Your Ref: EN020034  
Our Ref: Z004350

22nd September 2023

Between Creyke Beck Substation Cottingham East Yorkshire to High Marham Substation Nottinghamshire - Application by National Grid Electricity Transmission for an Order granting Development Consent for North Humber to High Marham Project

Reproduced from Ordnance Survey digital map data © Crown copyright 2023. All rights reserved. Licence number 0100031673.
© Environment Agency copyright and/or database right 2016. All rights reserved.

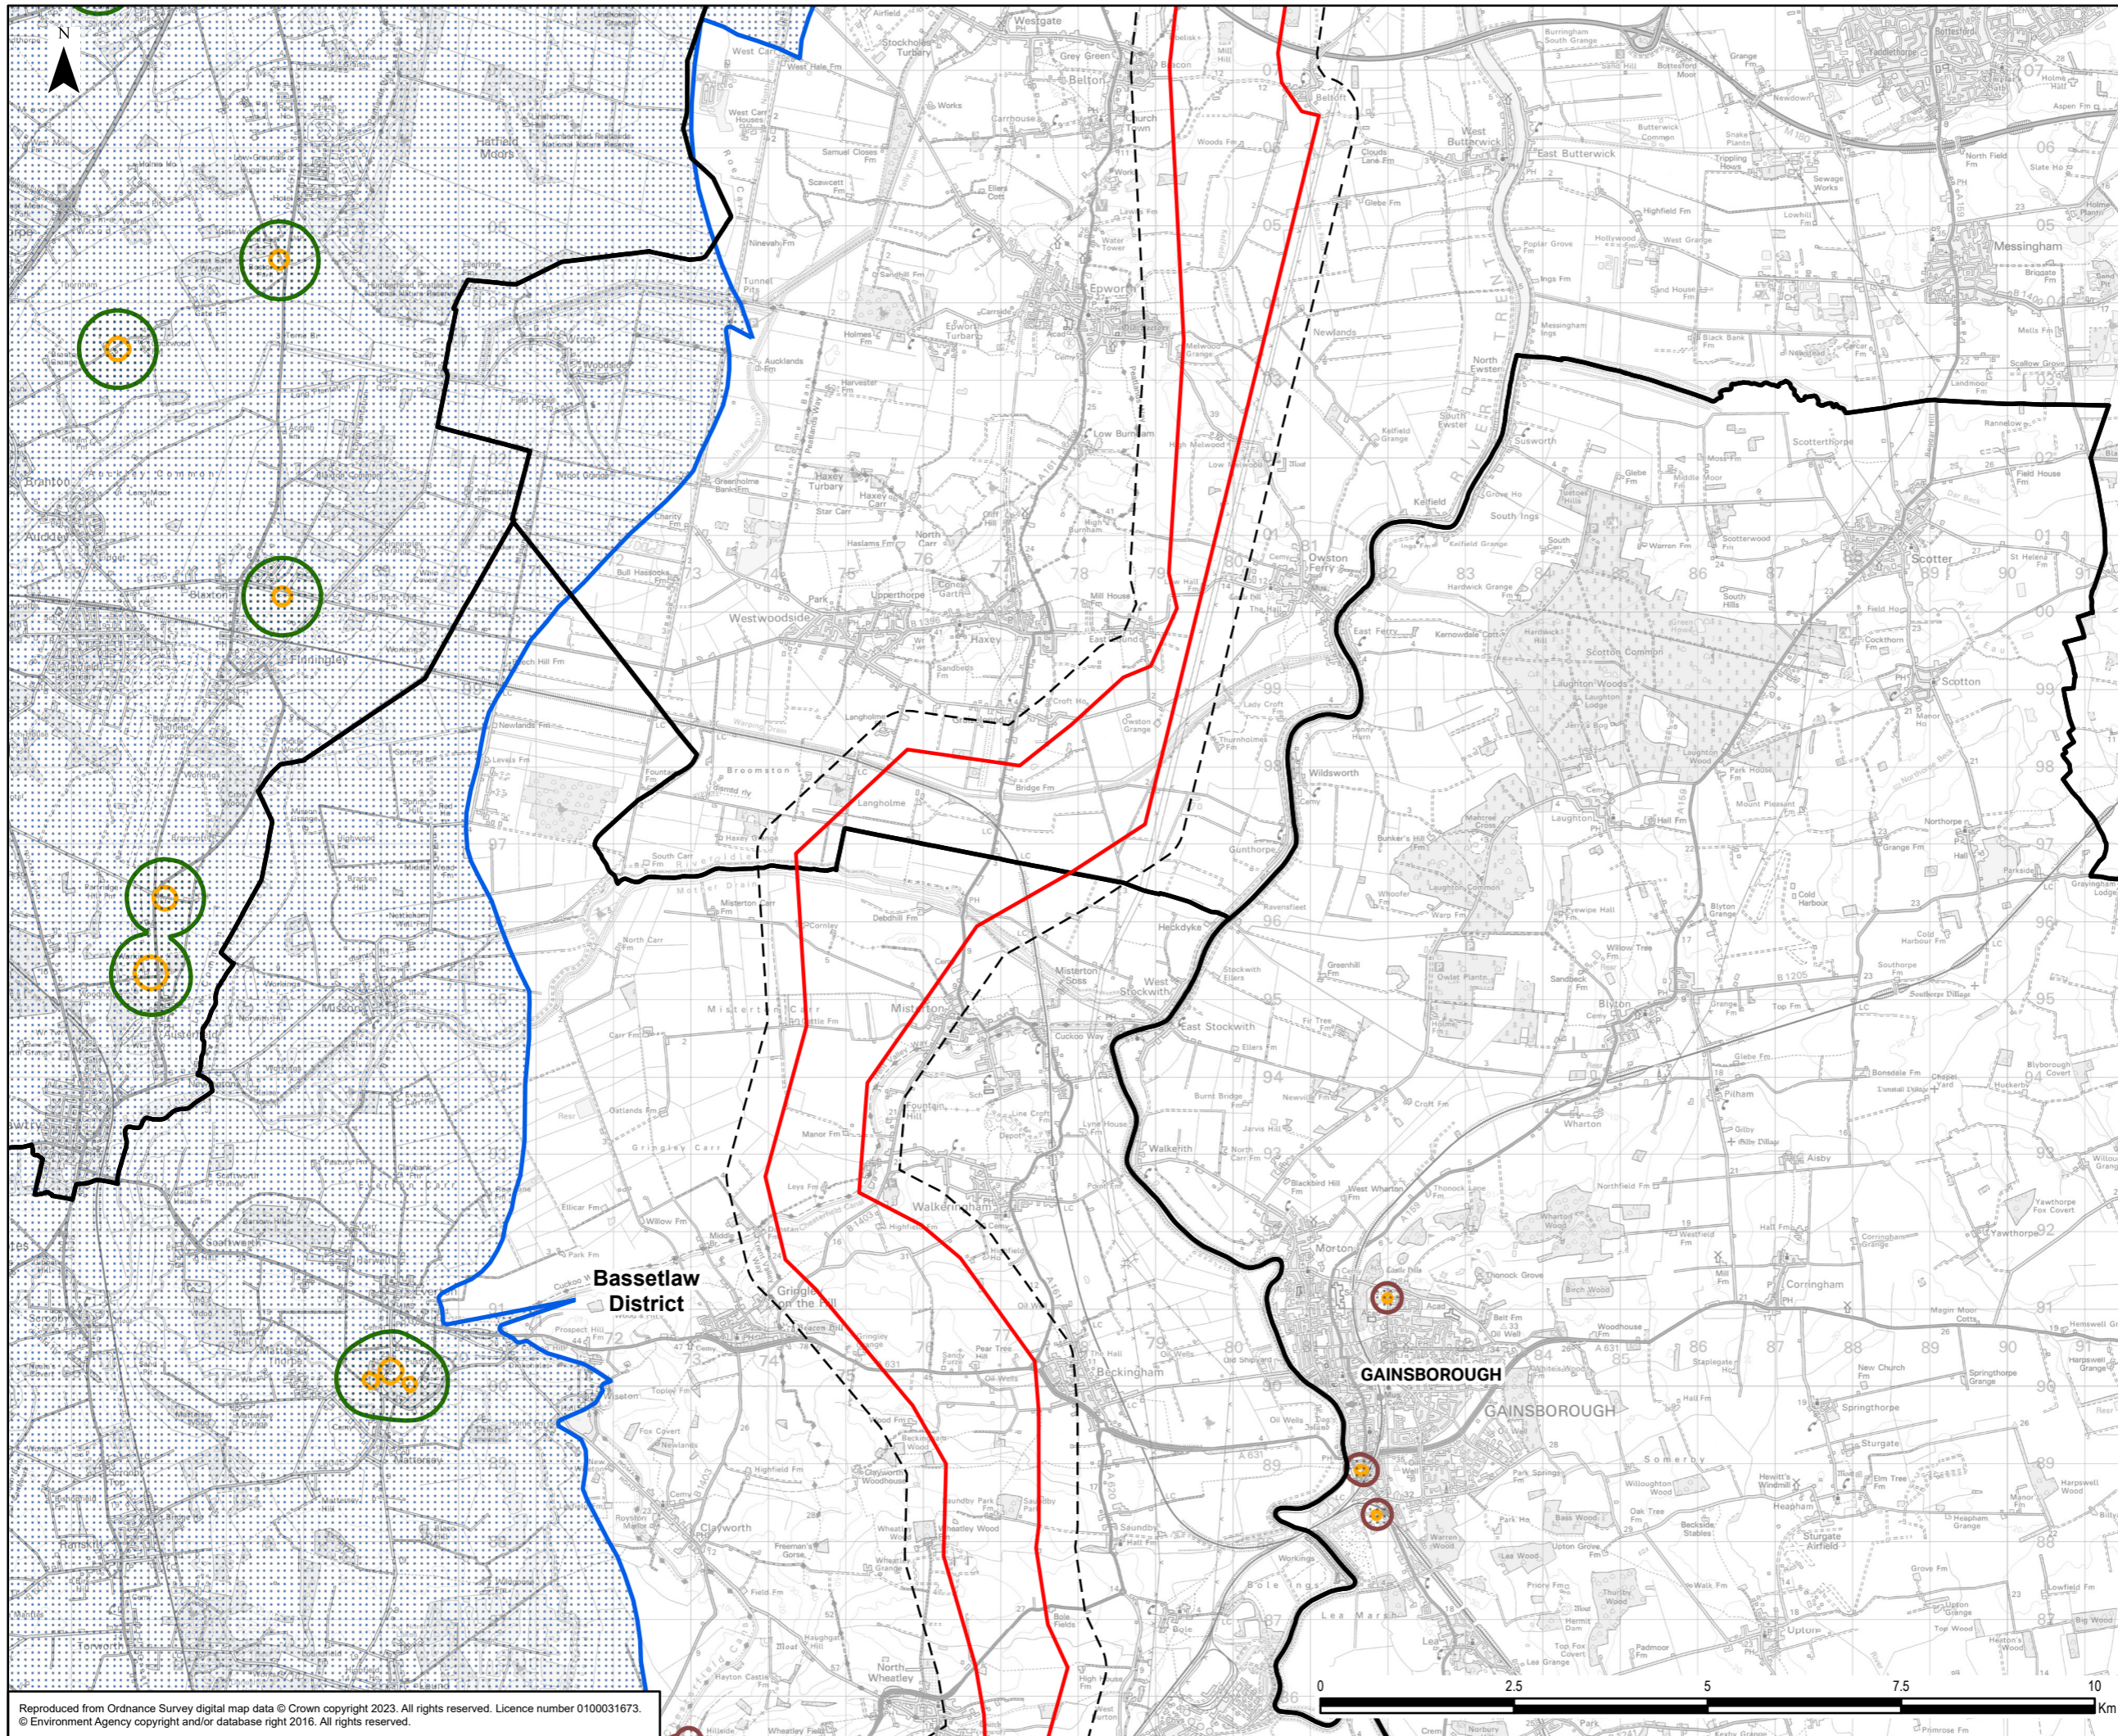
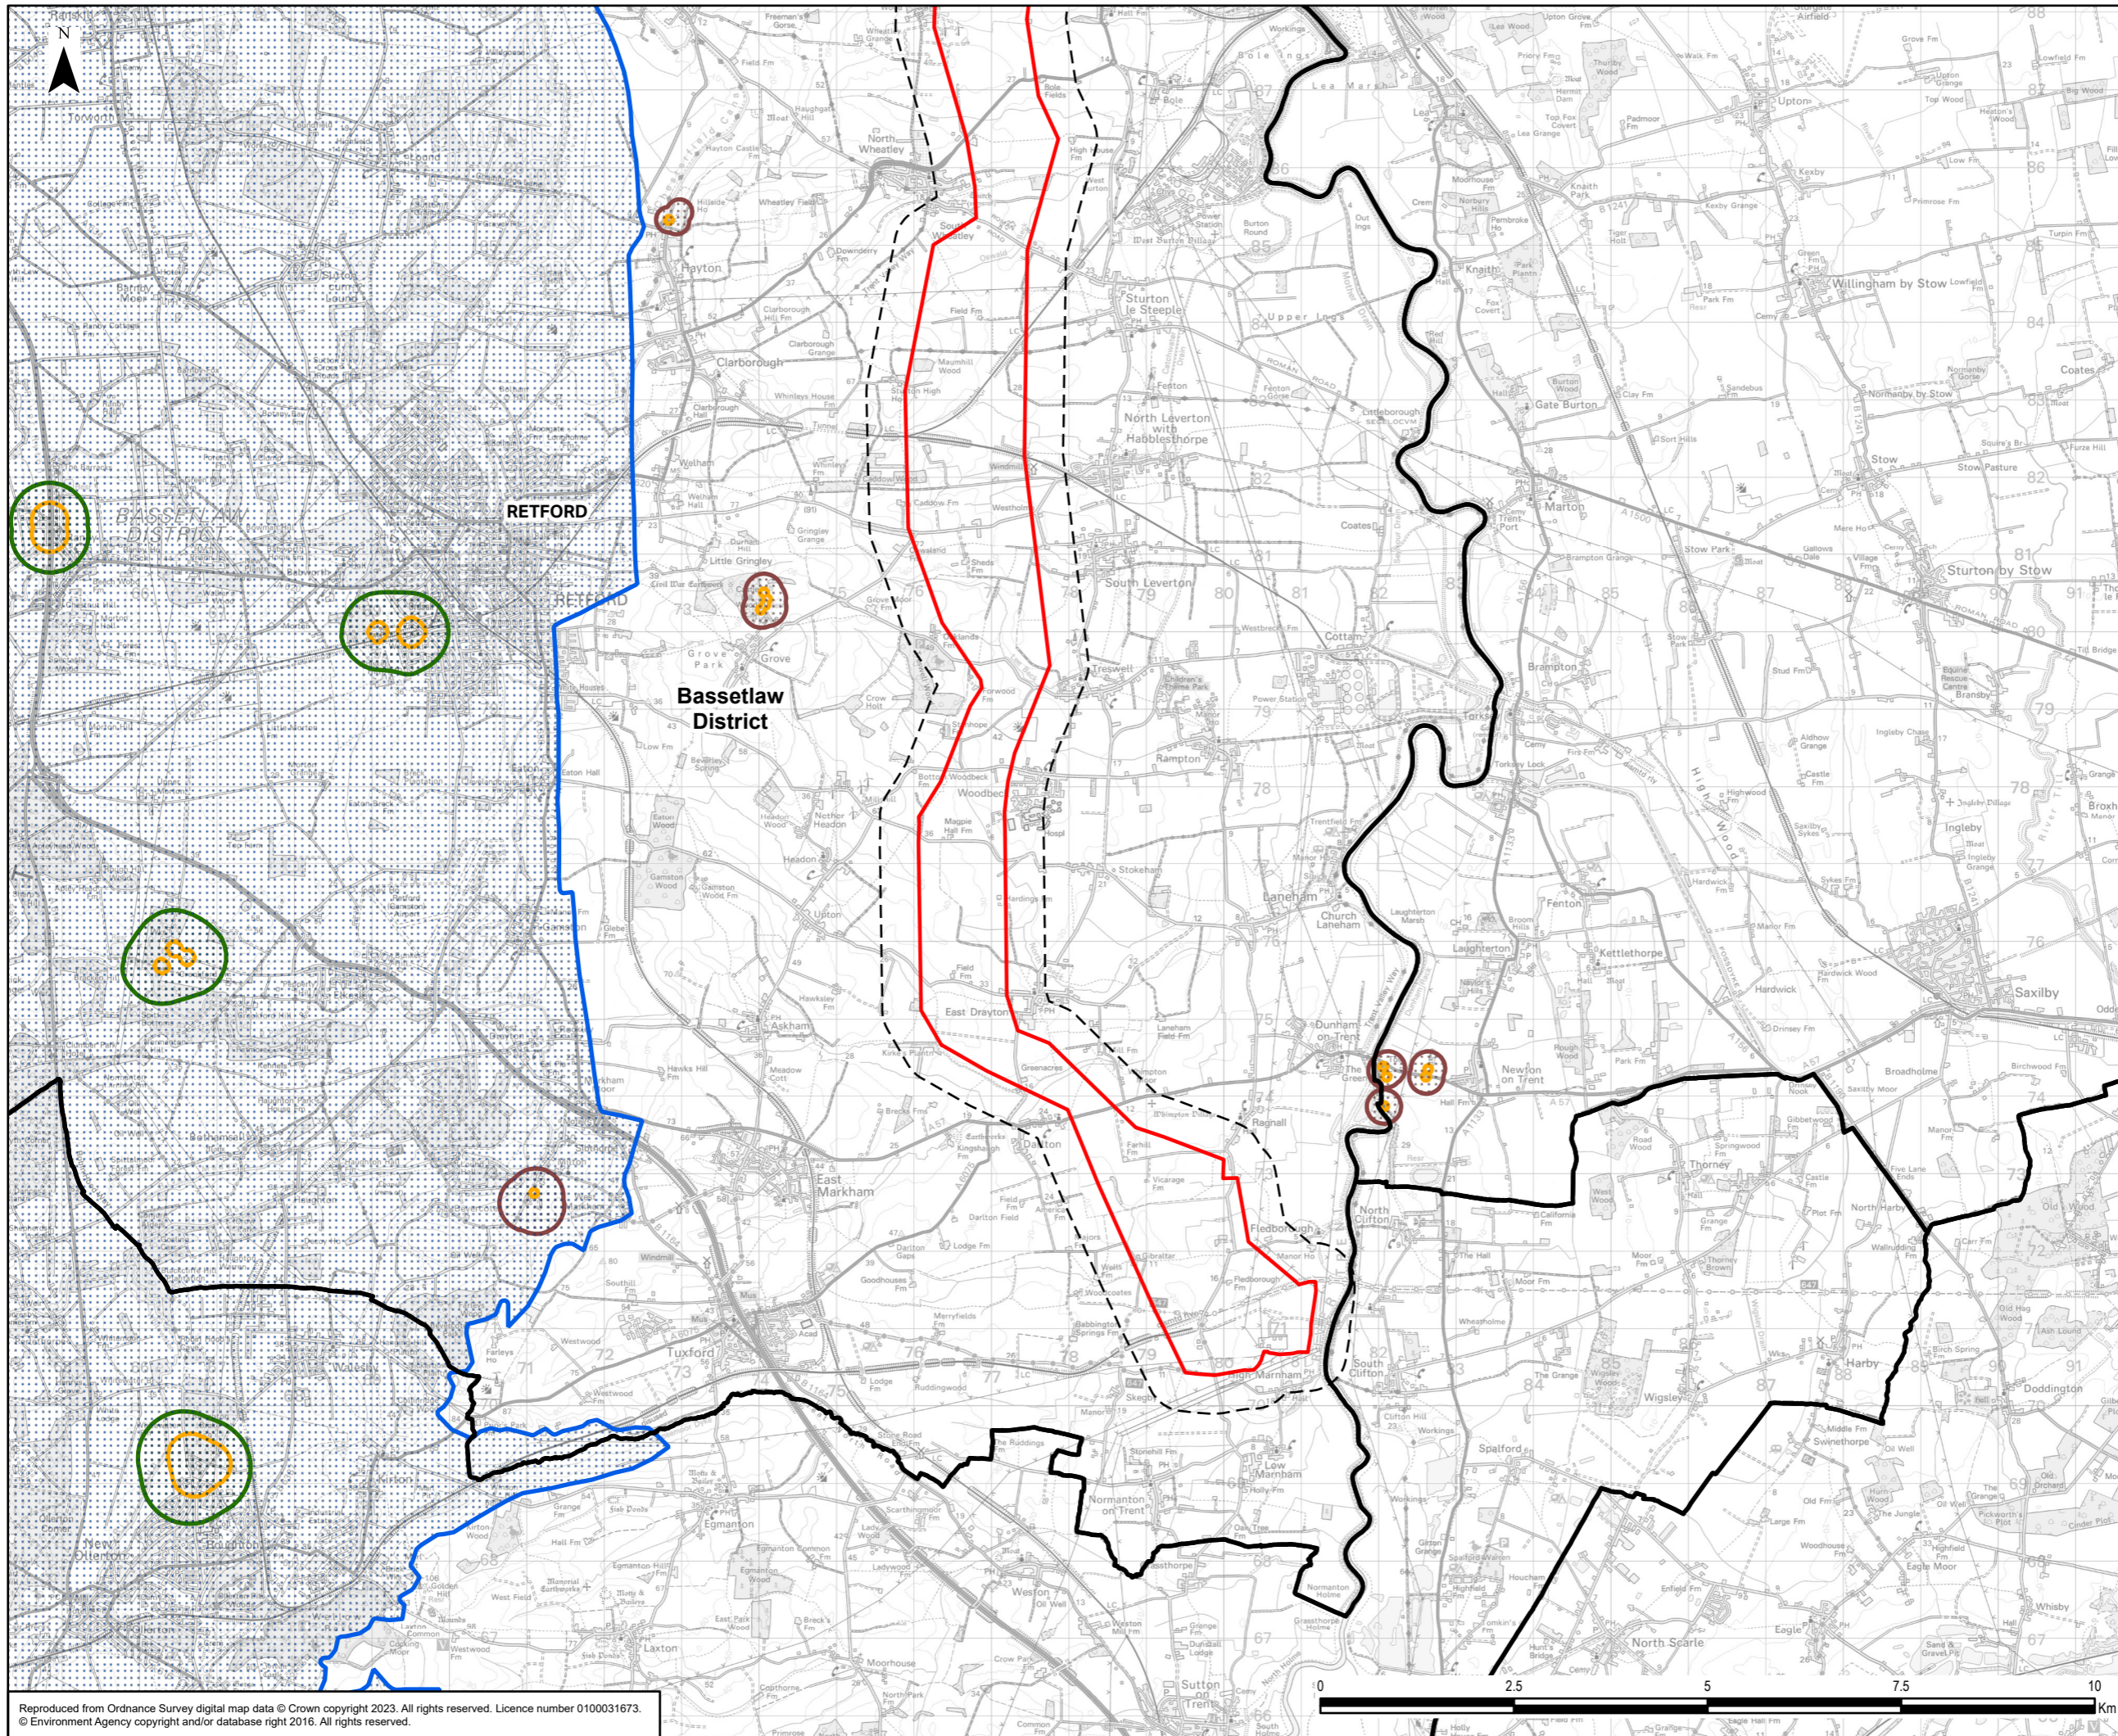
A small part of the identified scoping boundary passes through the separate SPZ1 areas of both Keldgate and Dunswell Source Protection Zones and the associated SPZ2 and SPZ3 zones for these protection areas. The EIA Scoping report Volume 1, ref: CGNC-NG-CNS-REP-0002 advises that majority of the geology and hydrogeology topic will be scoped out advising significant effects are unlikely with the proposed mitigation and control measures.

However, some elements of the geology and hydrogeology topic will be scoped in, including trenchless crossings. Trenchless crossing are not currently proposed although any significant effects on the SPZ zones as a result of intrusive ground works will be considered. The ES will also be supported by a CEMP detailing the use and storage of chemical and fuels. The scope of this chapter is acceptable to YW.
